Subject: FW: CM/56/19/PL - Concrete batching plant - Unit H6 Rudford Industrial Estate

I refer to the above planning application and make the following comments;

Noise;

Figure AS11466/TH1

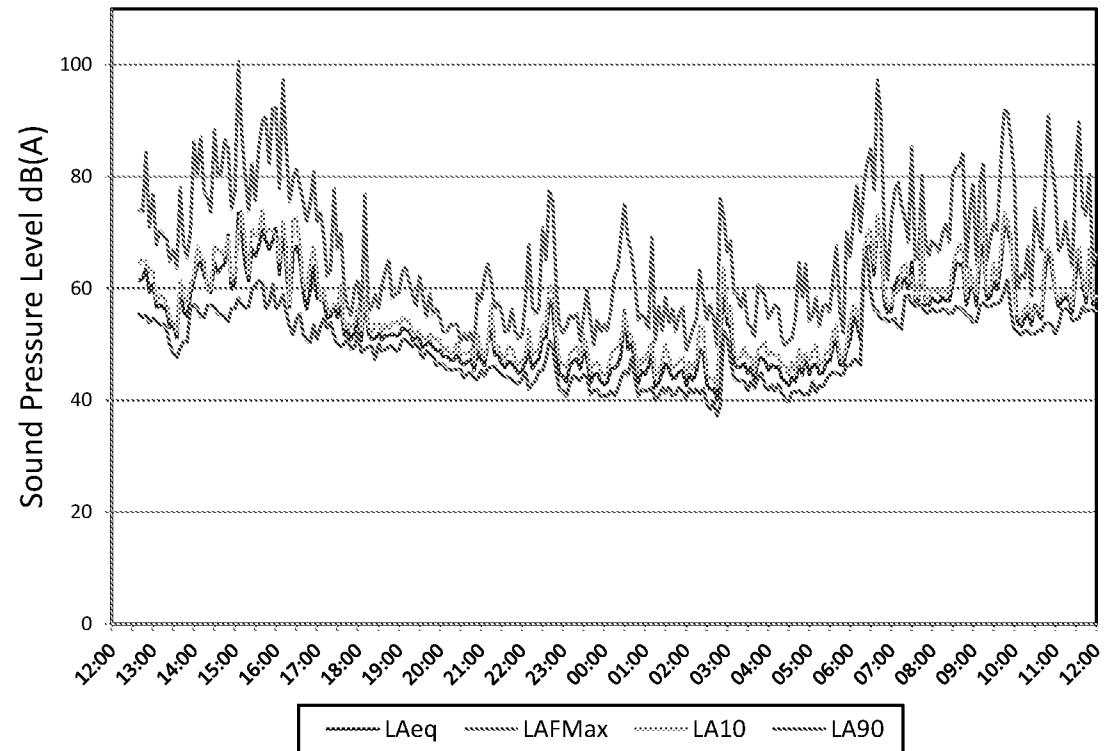
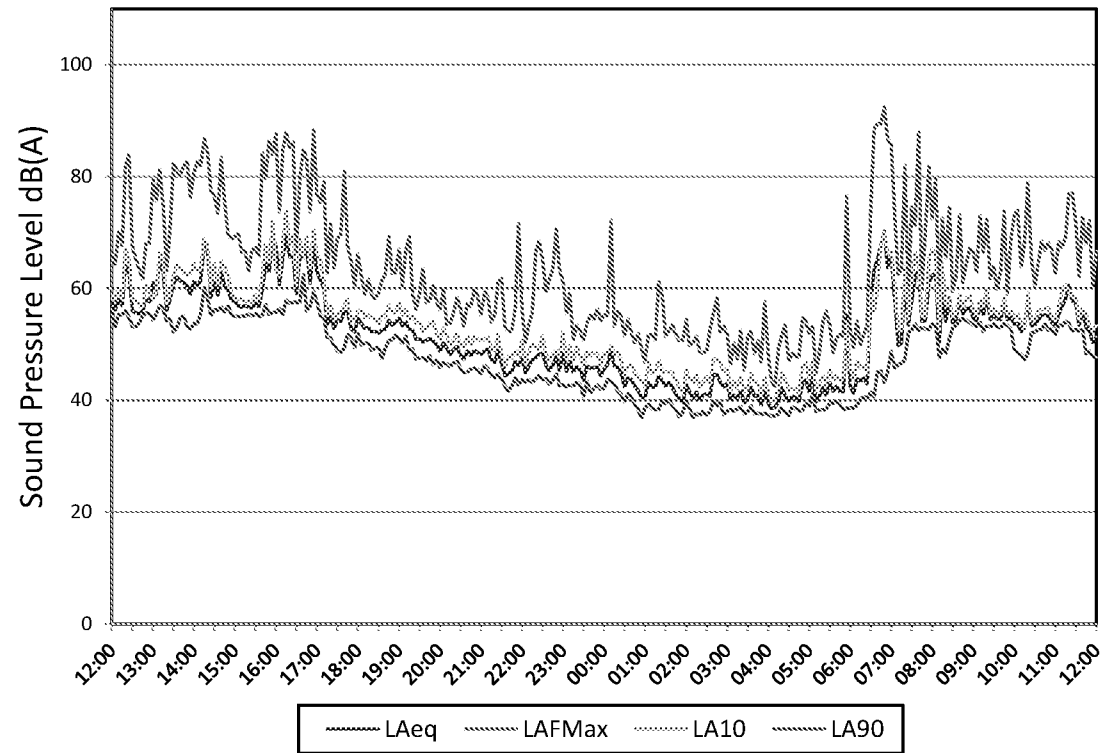
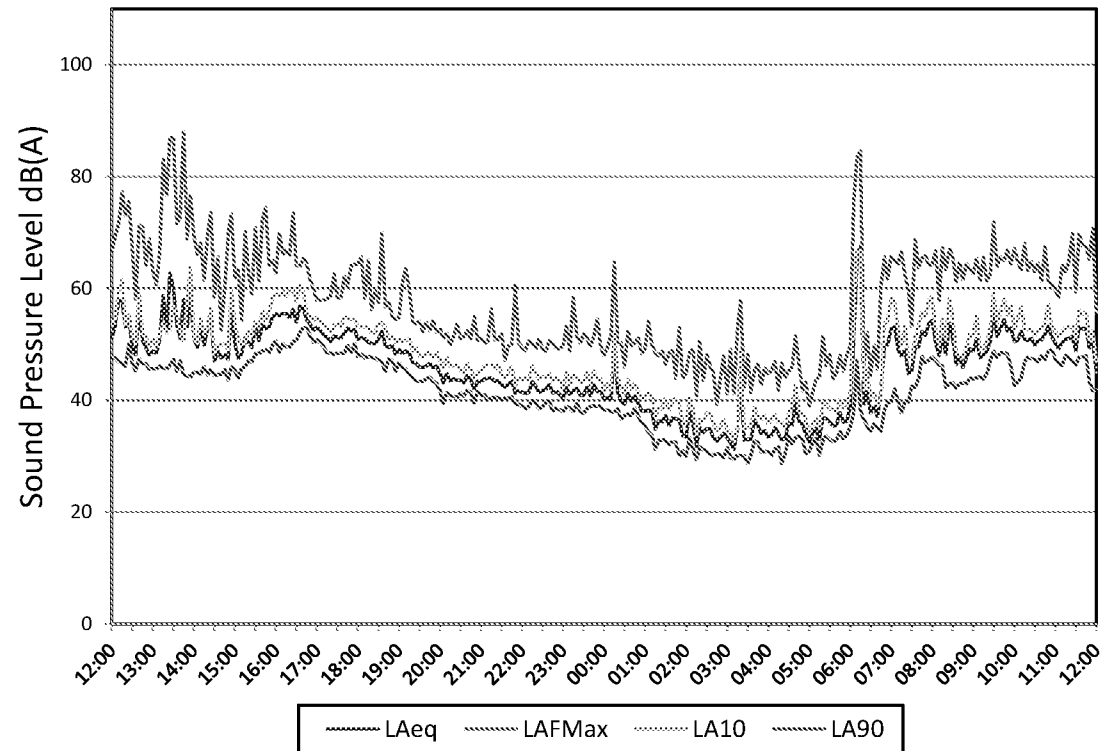
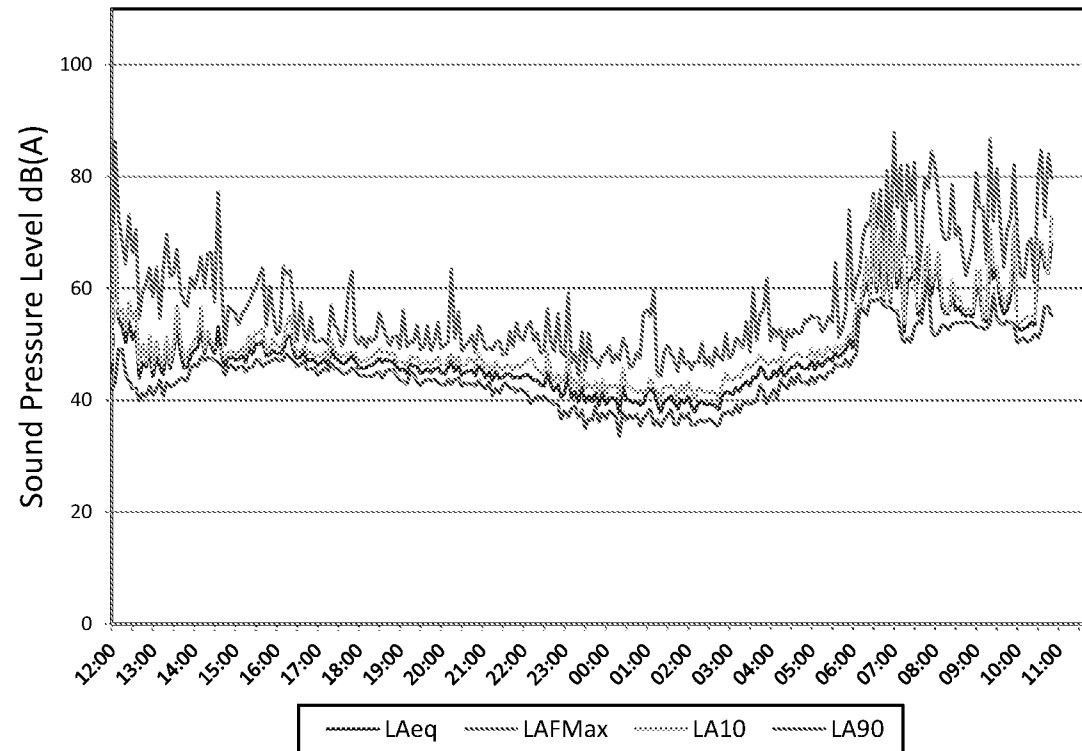
- The report states that environmental sound levels (i.e. background sound levels) were monitored at the boundary of the unit on the industrial estate. BS4142

8.1.2 Where possible, measure the background sound level at the assessment location(s). If this is not possible measure at an alternative location where the residual sound is comparable to the assessment location(s).

Please justify why background levels were not monitored at the assessment location which I would expect to have lower noise levels.
